WEST SUSSEX COUNTY COUNCIL CONSULTATION

TO:	<u>Arun</u> District Council <u>FAO:</u> Michael <u>Eastham</u> <u>CC:</u> <u>Cllr</u> Deborah <u>Urquhart</u>
FROM:	<u>WSCC</u> - Highways Authority
DATE:	16 July 2021
LOCATION:	Chandlers Garage <u>Bmw</u> House Water Lane <u>Littlehampton</u> <u>BN16 4EH</u>
SUBJECT:	A/110/21/PL Erection of retirement apartment with 20 No. 1 Bed flats & 13 No.2 Bed flats with communal facilities & car parking, erection of a retail store with car parking & associated highway works. This application affects the character & appearance of the Angmering Conservation area, affects the setting of listed buildings and is in CIL Zone 2 (Zero Rated) as other development.
DATE OF SITE VISIT:	Site known to officer
RECOMMENDATION:	Advice / More Information
<u>S106</u> CONTRIBUTION TOTAL:

PRELIMINARY SITE ACCESS ARRANGEMENTS

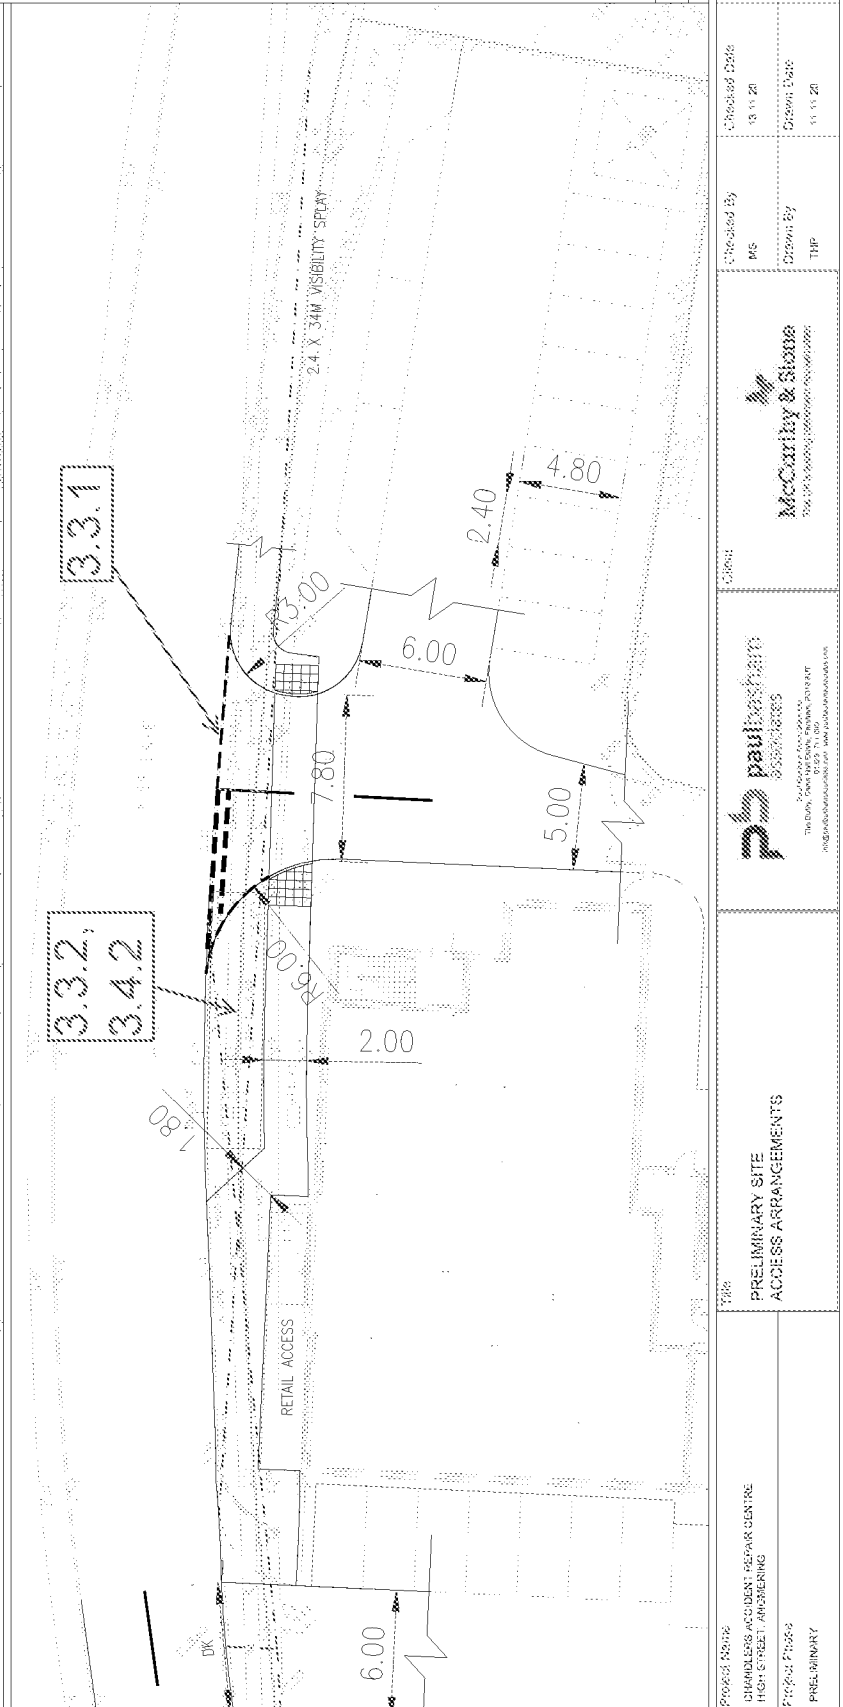
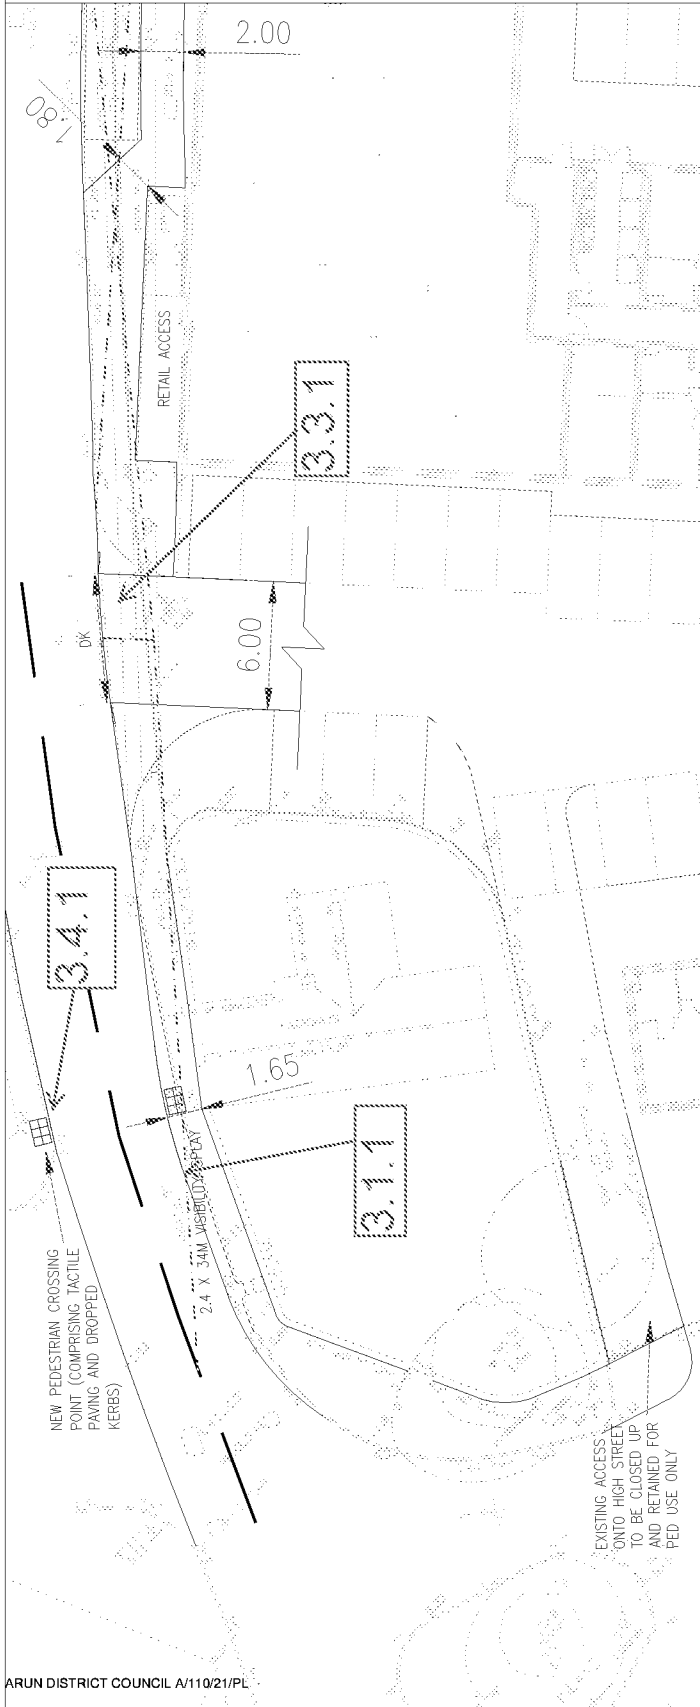
Drawing no: 034.0135.001 demonstrates the site with split access. One for the residential element which will be a formalisation of the existing access to the west, to form a cross over style access with an internal access road serving the car parking area. This is wide enough to allow the passing of two vehicles so traffic on the highway can remain free flowing.

Access to the convenience store to the east will also cater for access to a small proportion of parking spaces related to the residential side of the development, which will be segregated via a gate from the store parking area.

Additional tactile paving and dropped kerbs will be provided at the bell mouth access on Water Lane to improve pedestrian connectivity and safety.

Under section 3.6 it is proposed that the footway will be widened to approx. 1.8m west of the site and a minimum of 1.65m within the vicinity of Eachways to the west, with this being achieved by narrowing the carriageway. This section of Water Lane already has a pinch point in the vicinity of Eachways, the LHA would require a detailed plan indicating the exact new carriageway width and footway widths for review. Site pedestrian access is also being provided directly onto High Street, via the old vehicle access being closed off to vehicles but left as pedestrian only access.

Project Name	CHANDLER'S ACCIDENT REPAIR CENTRE HIGH STREET / ANDOVERING	Title	DELIVERY AND SERVICING BAY ARRANGEMENTS	Client	Paul Basham 034 0135 003	Project Drawing No	034 0135 003	Revision	A
Project Phase	PRELIMINARY	Drawn Date	11.11.20	Drawn By	TJP

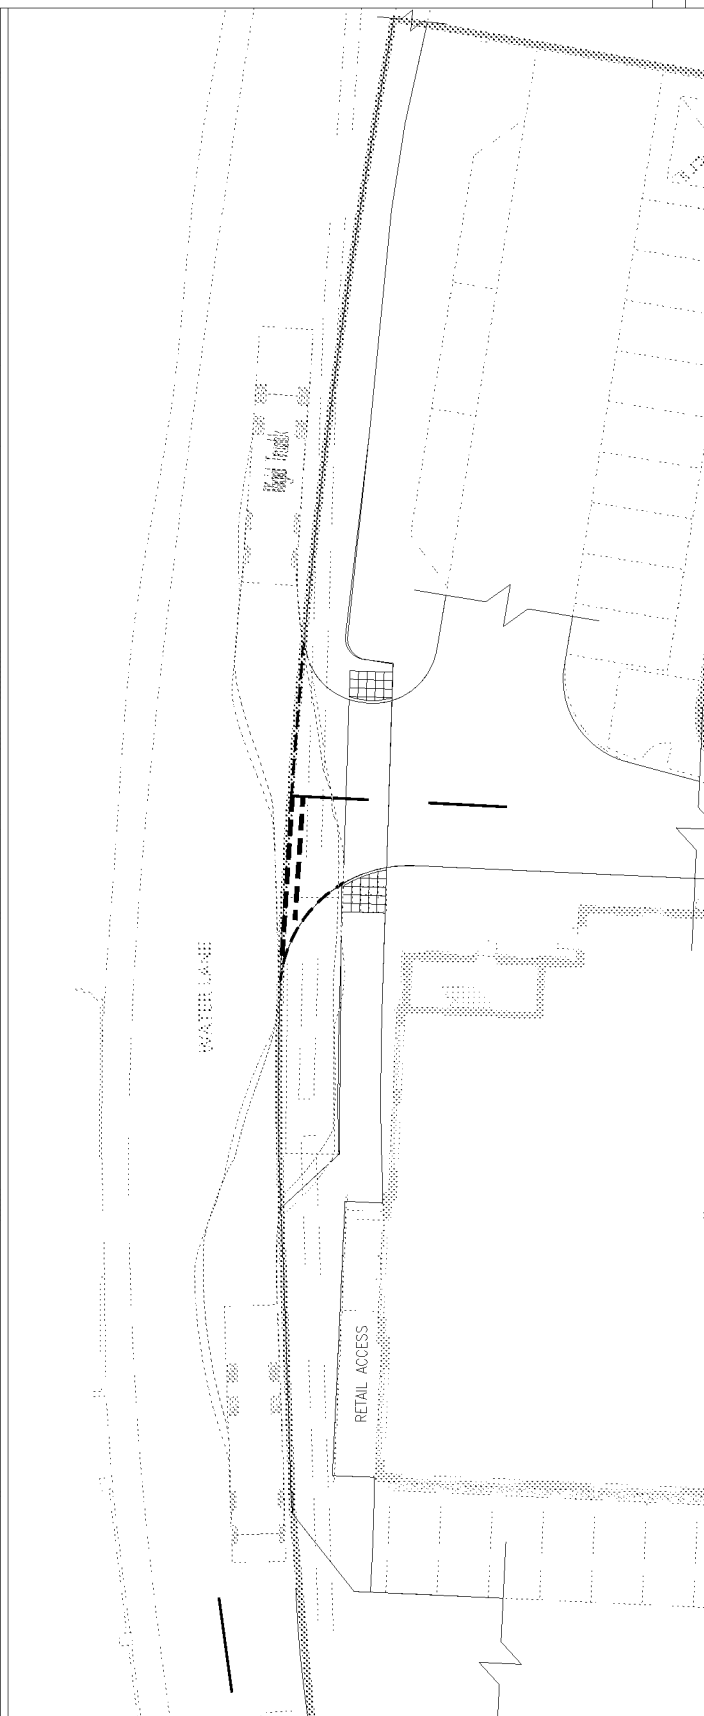
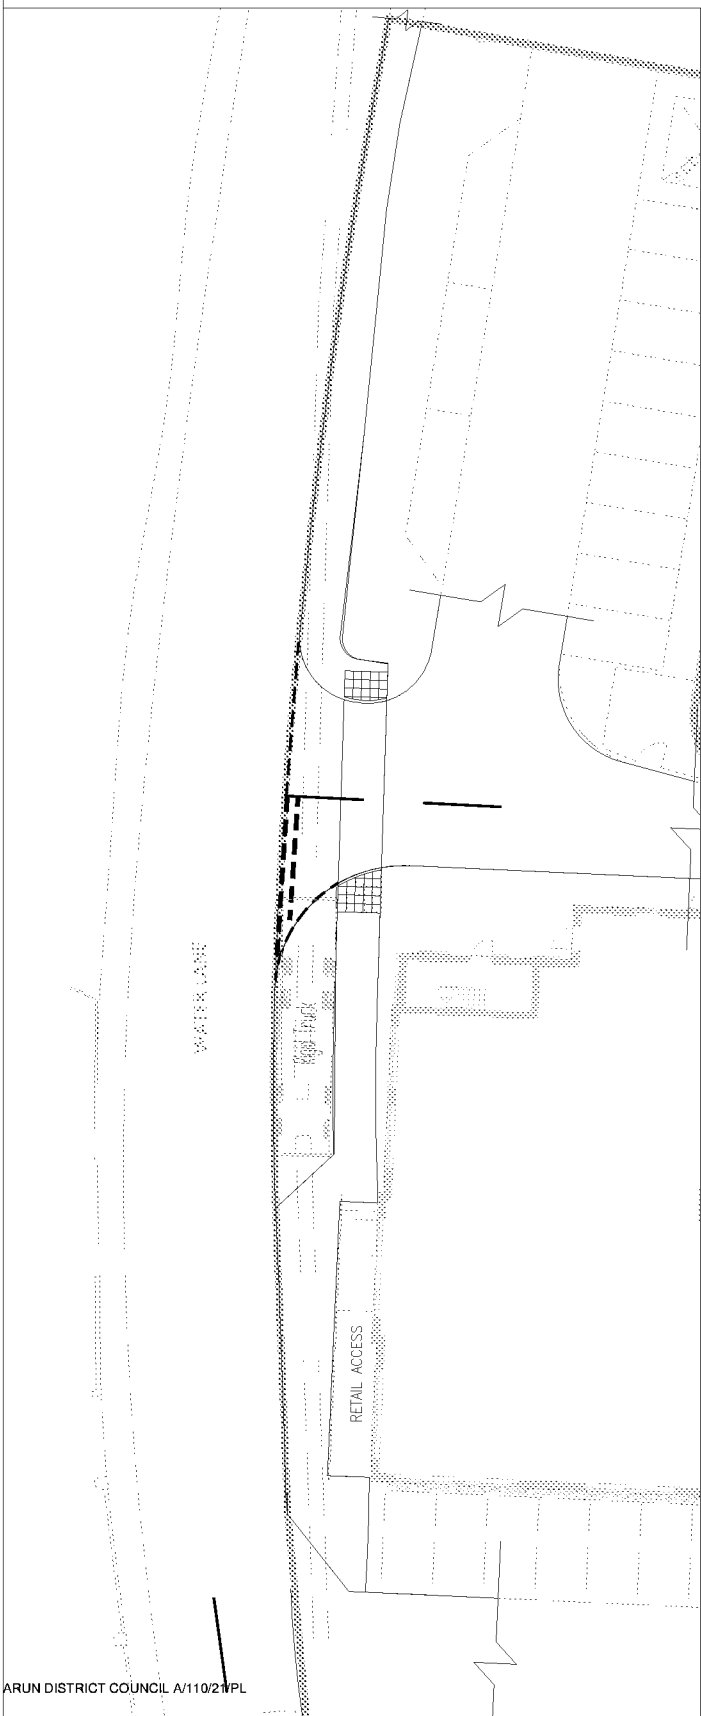
- Problem 3.3.1 – Movement of larger vehicles at access onto Water Lane – The LHA are in agreement that the vehicle tracking provided demonstrates that the bell mouth access to the convenience store and the refuse collection store for the retirement flats is able to support the once a week infrequent movement of a refuse vehicle, given the low speed environment and the context of Water Lane it is not expected that the occasional small over running of the centre line will lead to a safety concern.
